PLANNING BOARD REPORT PORTLAND, MAINE

Residential townhouse - 6 unit condominium
133 York Street
Level III Site Plan and Subdivision
Project ID 2013-187
133 York, LLC, Applicant

Submitted to: Portland Planning Board Public Hearing Date: November 12 th , 2013	Prepared by: Jean Fraser, Planner Date: November 8 th , 2013 Planning Board Report # 50-13
---	--

Drawing file: Final Plans for hearing Report / Att. 6 - Erosion Control & Landscape Plan.pdf

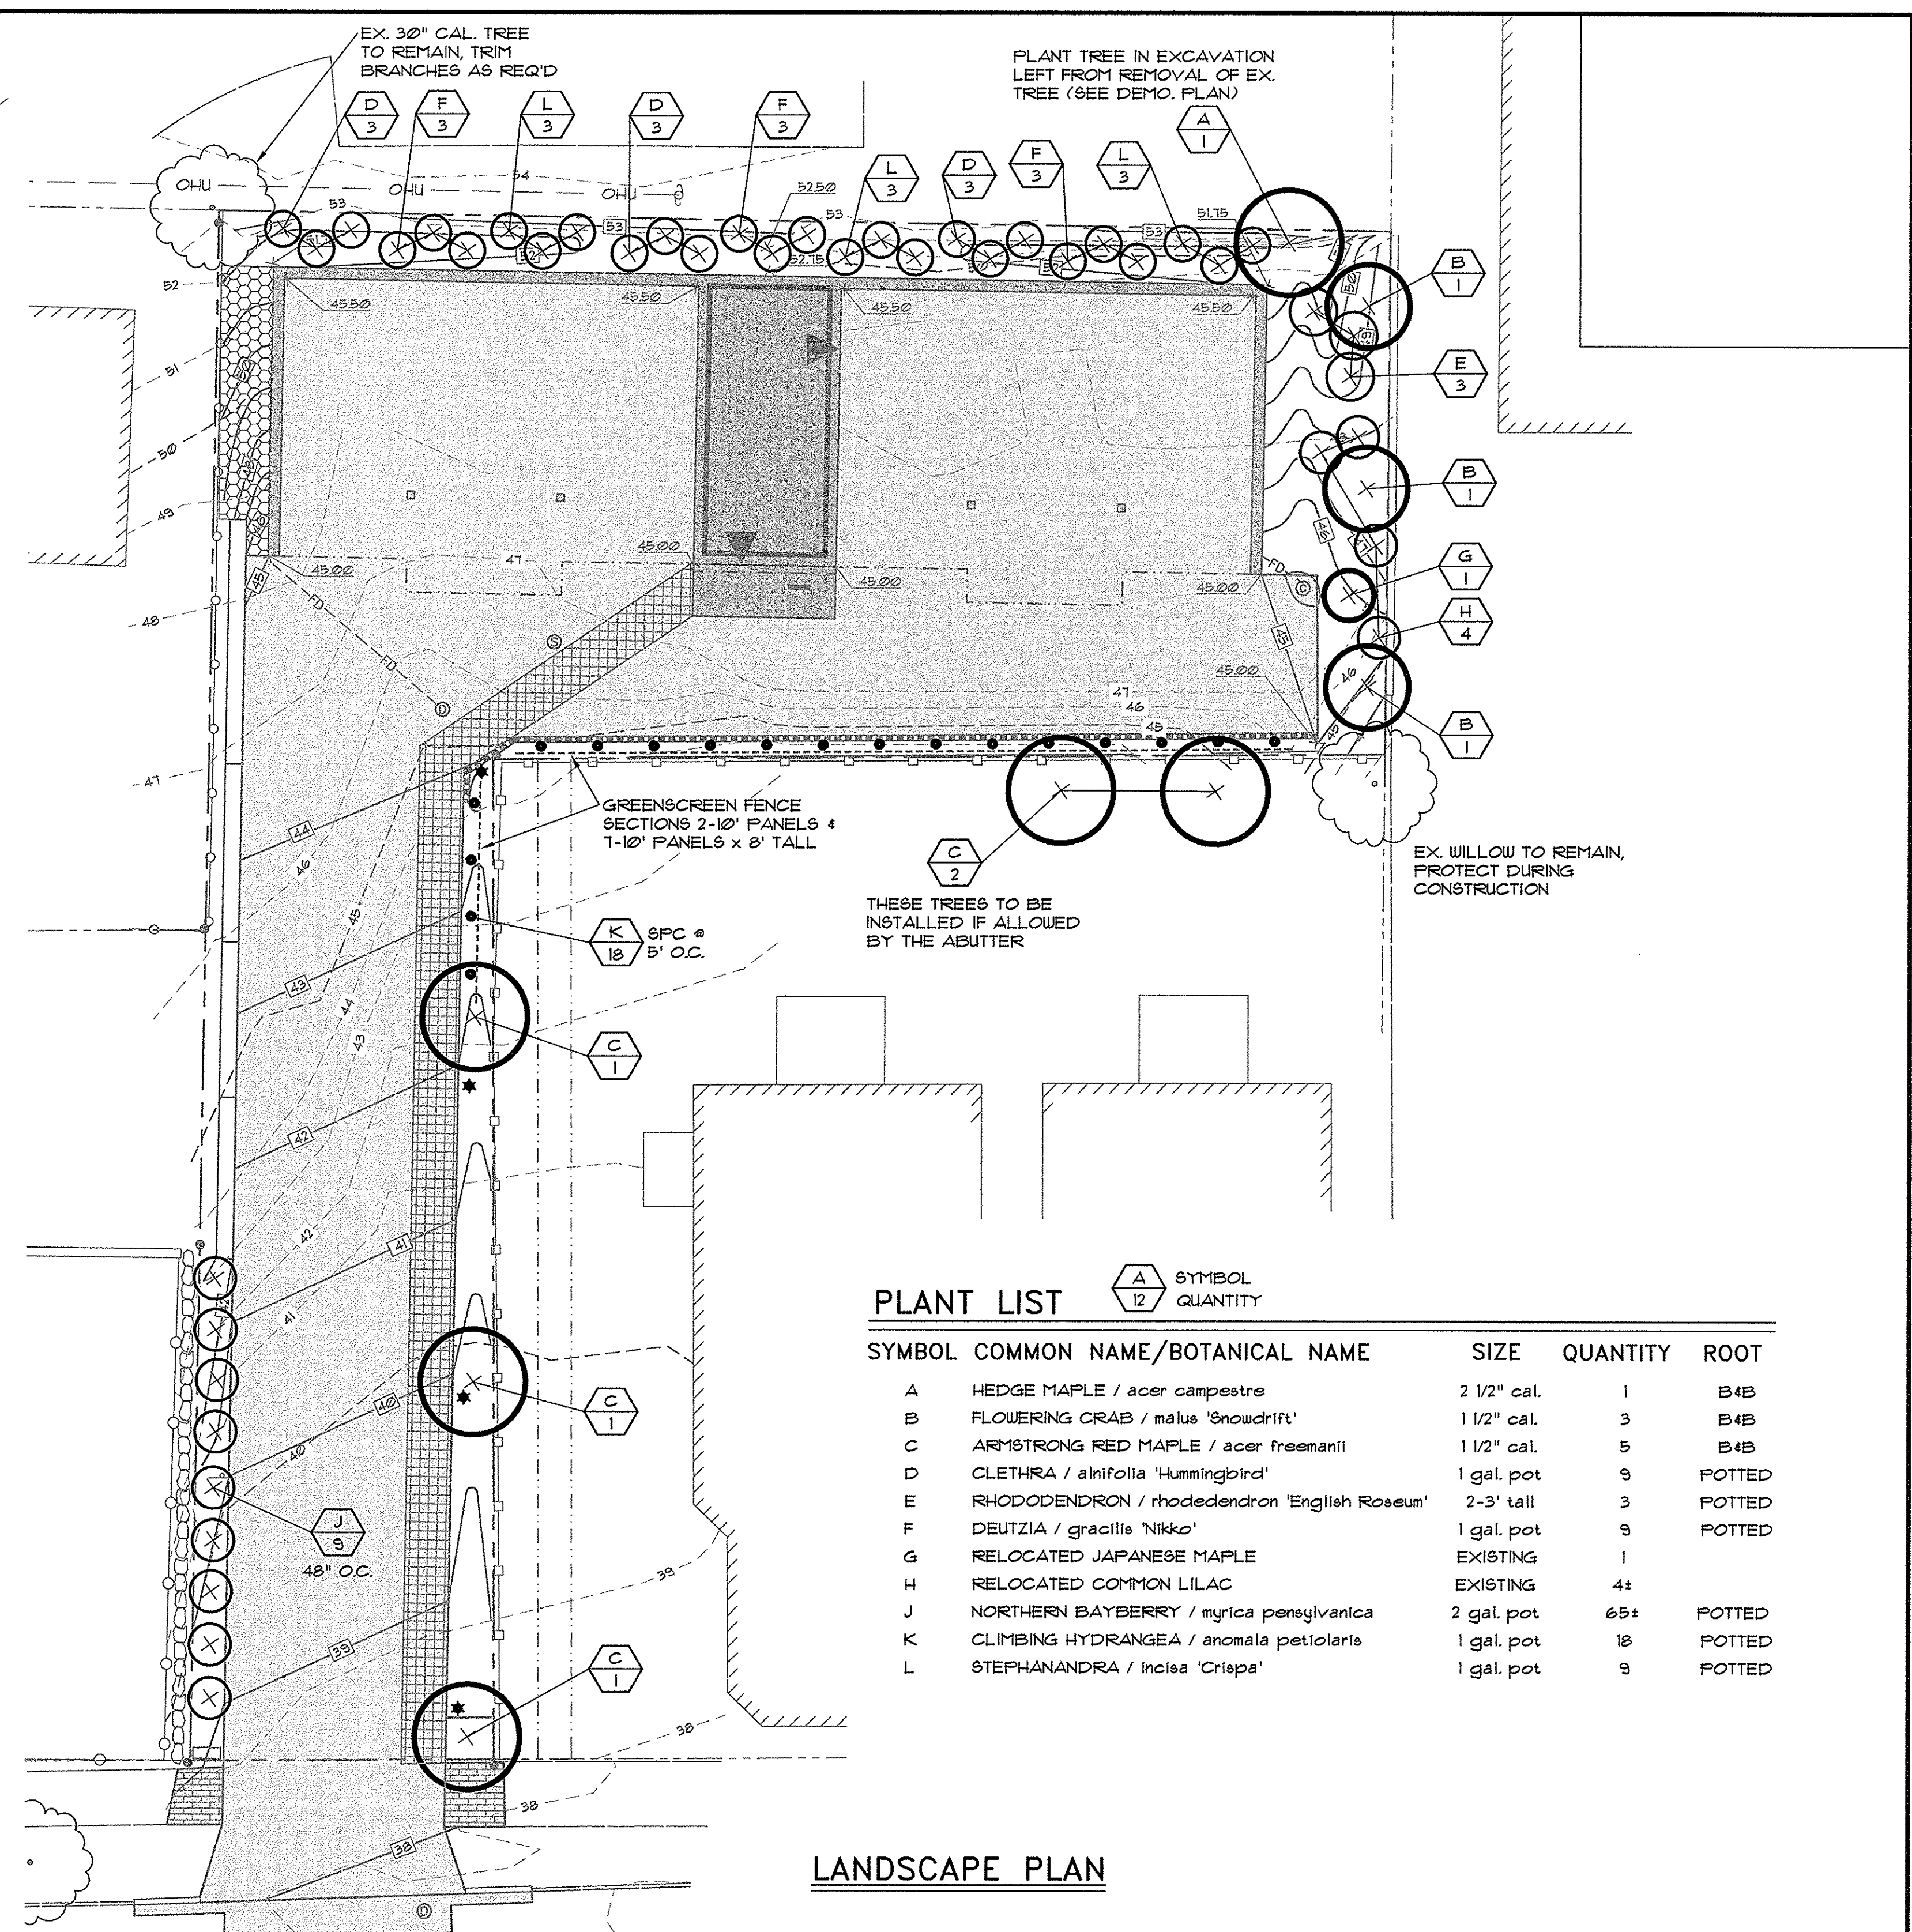
The City Arborist, Jeff Tarling, has commented (Attachment 11):

*a) **Landscape review** - The proposed development at 133 York Street presents challenges to meet standard landscape treatment due to the shape and constraints of the project site. The project does offer landscape amenities such as a green wall to provide screening along with two off-site tree planting locations if agreeable. The building footprint close to existing building site poses challenges to screen but improves on the long existing conditions. Two mature trees are close and will likely have impact during the construction process. Best practices in regards to tree protection are needed to prevent / reduce root zone damage.*

*b) **Landscape plant material: plant sizes - Condition**) shrub stock noted as "D" Clethra, "F" Deutzia, "J" Northern Bayberry, "K" Climbing Hydrangea, "L" Stephanandra shall all be #3 pot size minimum and tree sizes should be the following: "B" Flowering Crabapple 1.75-2" caliper, "C" Armstrong Red Maple 2" caliper. Items mentioned as "Existing", "G" Relocated Japanese Maple (#5 pot size), "H" Relocated Lilac (3-4'H) should also have these sizes as replacements if the relocation is not successful. (Too often good intent to save plants through construction are less than successful).*

*c) **Green wall** - the proposed project use of a green wall will help screen / buffer the adjacent building. The green wall plant type: Climbing Hydrangea is slow growing, and thus the proposed 1 gallon pot size much to small to be effective for many years... recommendations & condition the green wall plant sizes must be #3 pot & #5 pot sizes alternating minimum to provide a good start for the green wall. (from 11.4.2013 comments): A solid screen such as a fence, would not, in my view, improve the proposed.*

A potential condition of approval requires the revision to the Landscape Plan to incorporate these recommendations.

Drawing file: Final Plans for hearing Report / Att. 10 - Tree Filter Detail.pdf

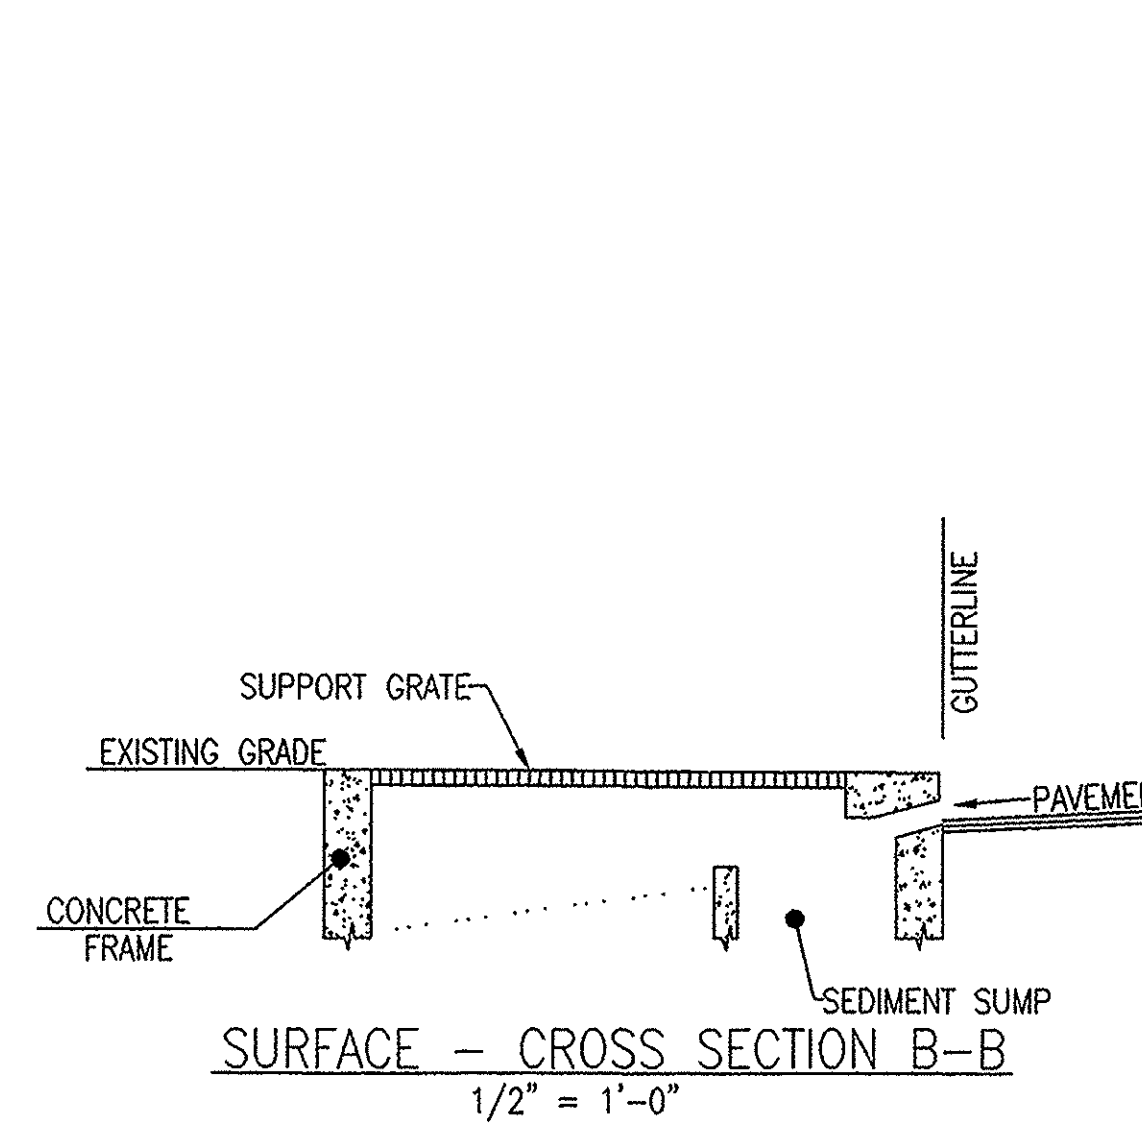
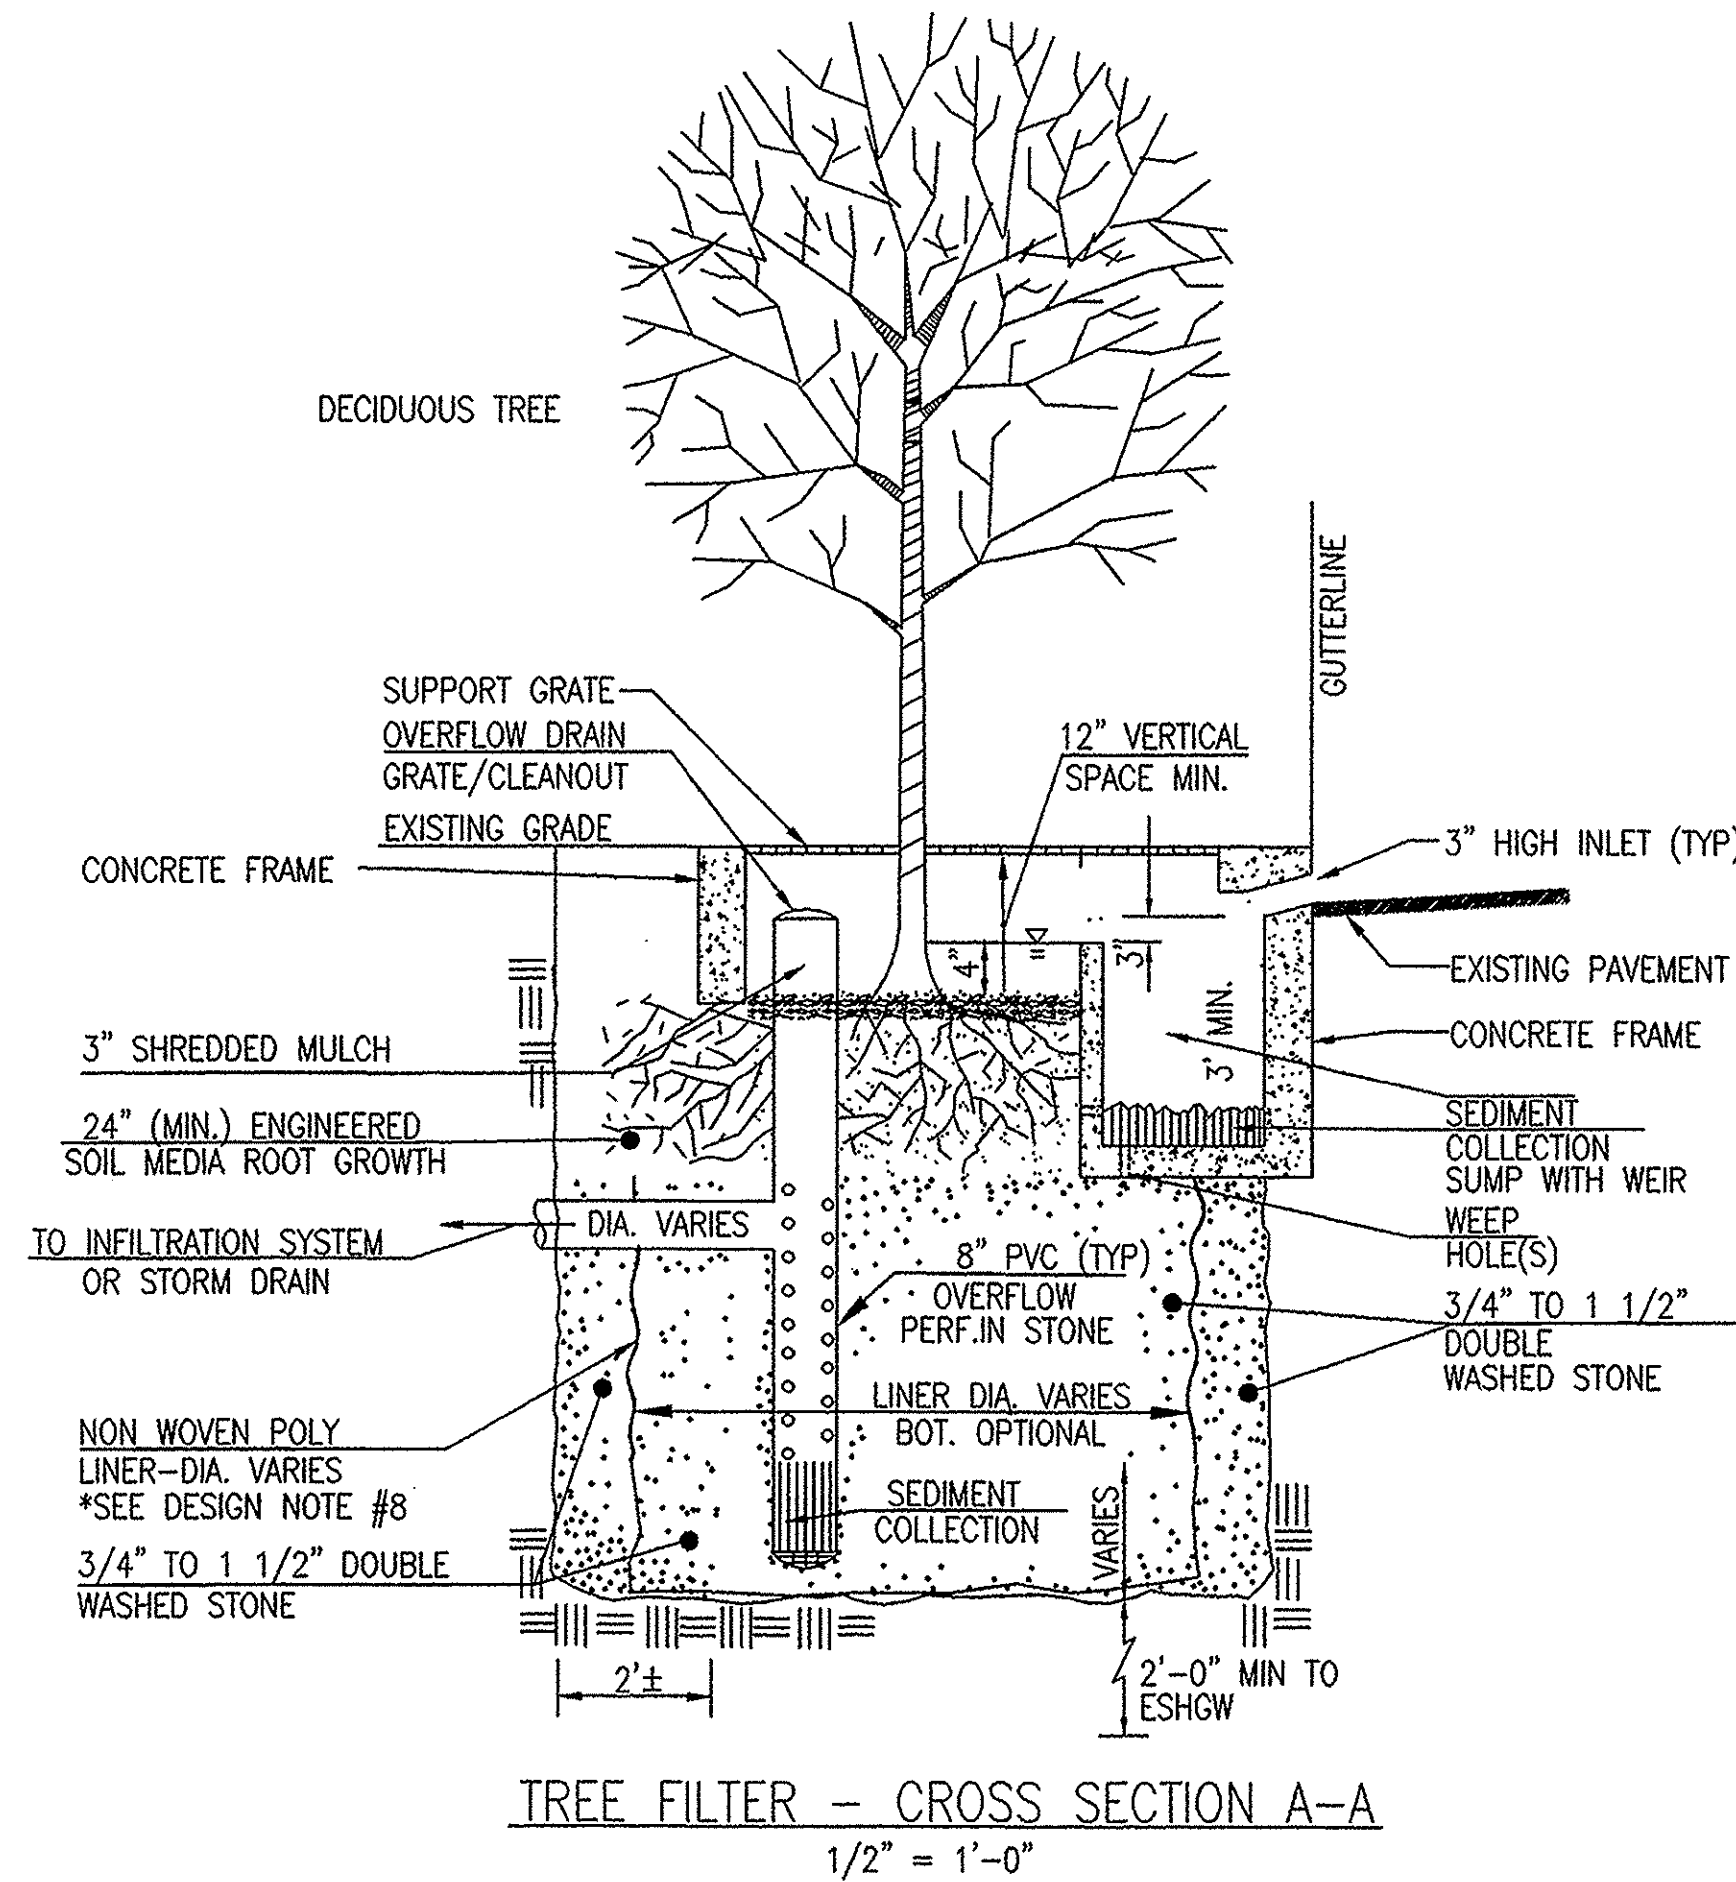
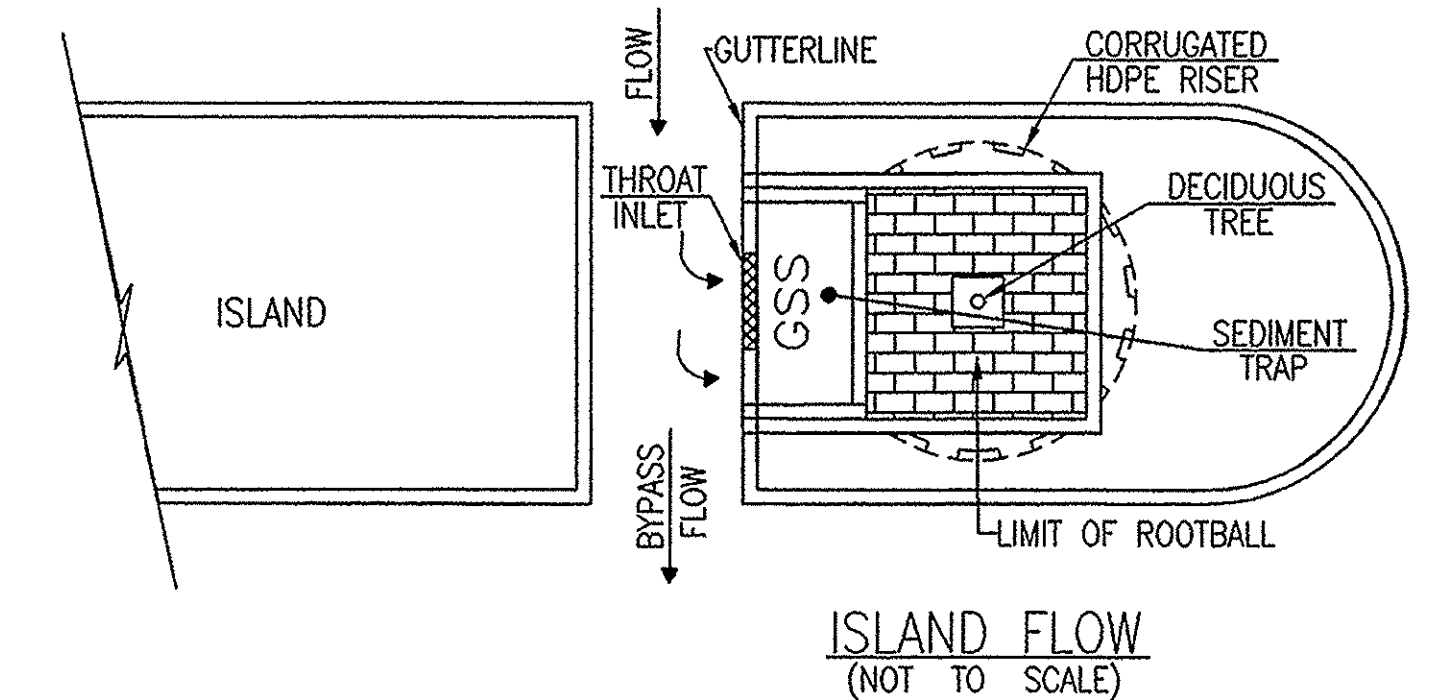
The proposals propose to manage stormwater impacts by collecting the stormwater and directing it to a tree filter system, which also allows for some quality treatment. The applicants have provided revised plans and supplementary stormwater information ([Attachment W](#)) and these are considered satisfactory ([Attachment 12](#)). The Department of Public Services considers the storm drain system in York Street is adequate to handle the proposed project drainage and has no comments regarding the proposed sewer connections.
